ur Case Number: ABP-320946-24

Re: Development at Long Point, Lake Road (R351)
Knockanima, Loughrea, County Galway

A submission concerning Loughrea Long Point Amenity Enhancement Part 10

## REFURBISHMENT OF SLIPWAY

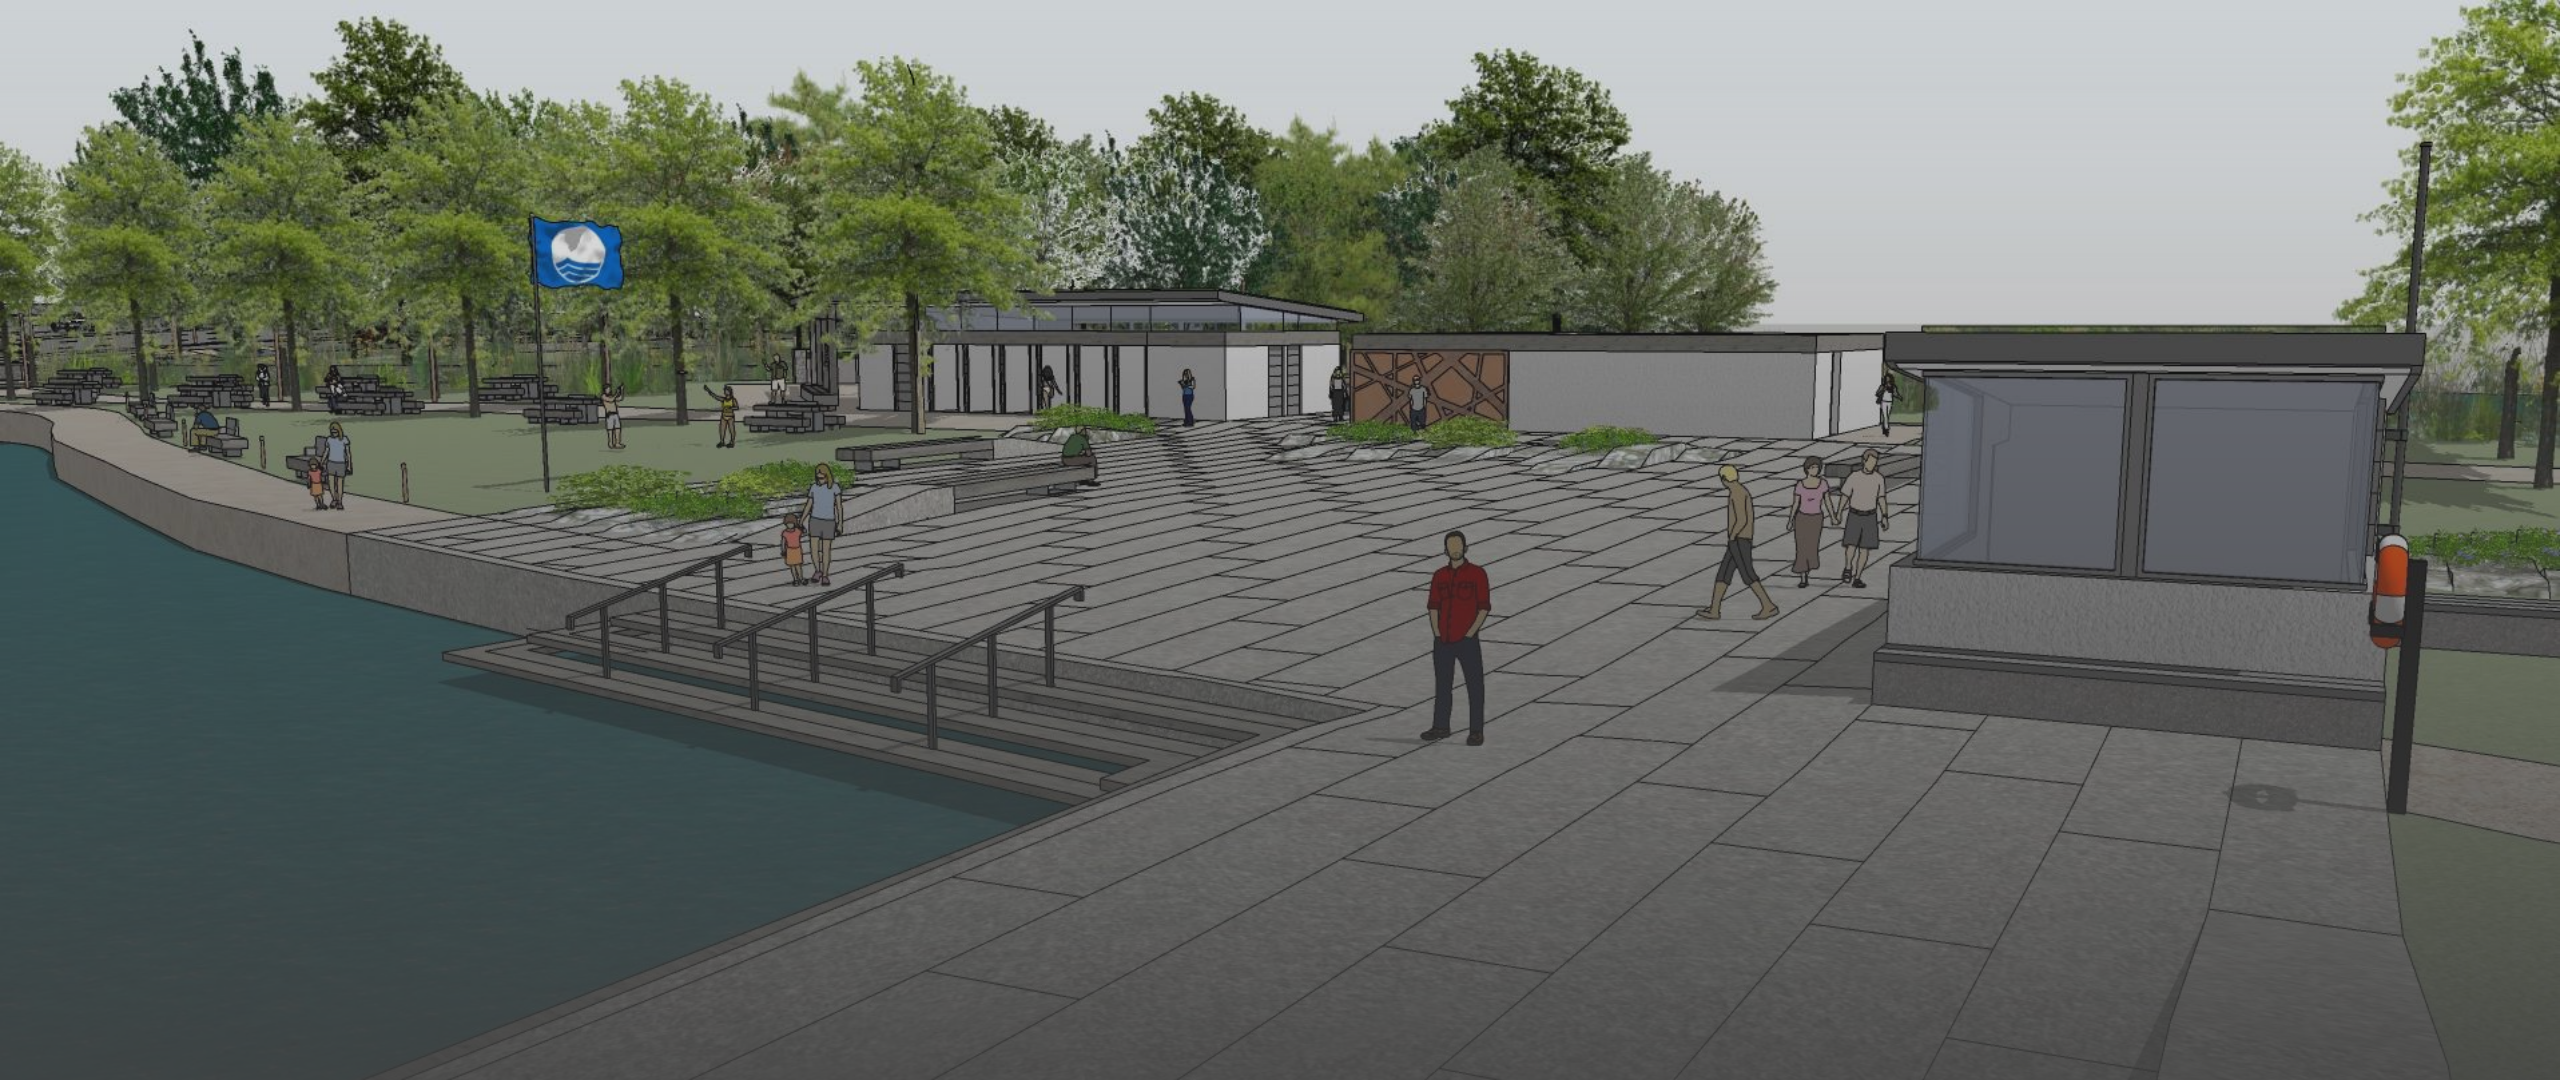
On Inspection of the proposed development documents I notice that there is a plan view showing the proposed slipway but no section view or side view of the proposed slipway for kayak and paddle boards. Hence one is not able to ascertain exactly what is proposed.

At present there is a no proper slipway with an appropriately inclined slope to reach a water depth of 1.5 m plus on the lake shore. The present construction beside the council offices has a very short ramp leading on to a concrete slatted shed floor section resting on rocks and stones followed almost immediately by a sudden drop into water of a depth of more than 2m. The shore line on the north side of lake in this region is the result of progressive back filling especially in the last 180 years which

- (1) 7m hardstanding in line with the slipway
- (2) 3m level concrete base
- (3) 2m(horizontal) concrete base at gradient 1: 8
- (4) 5.5m(horizontal) concrete base at a gradient 1:4
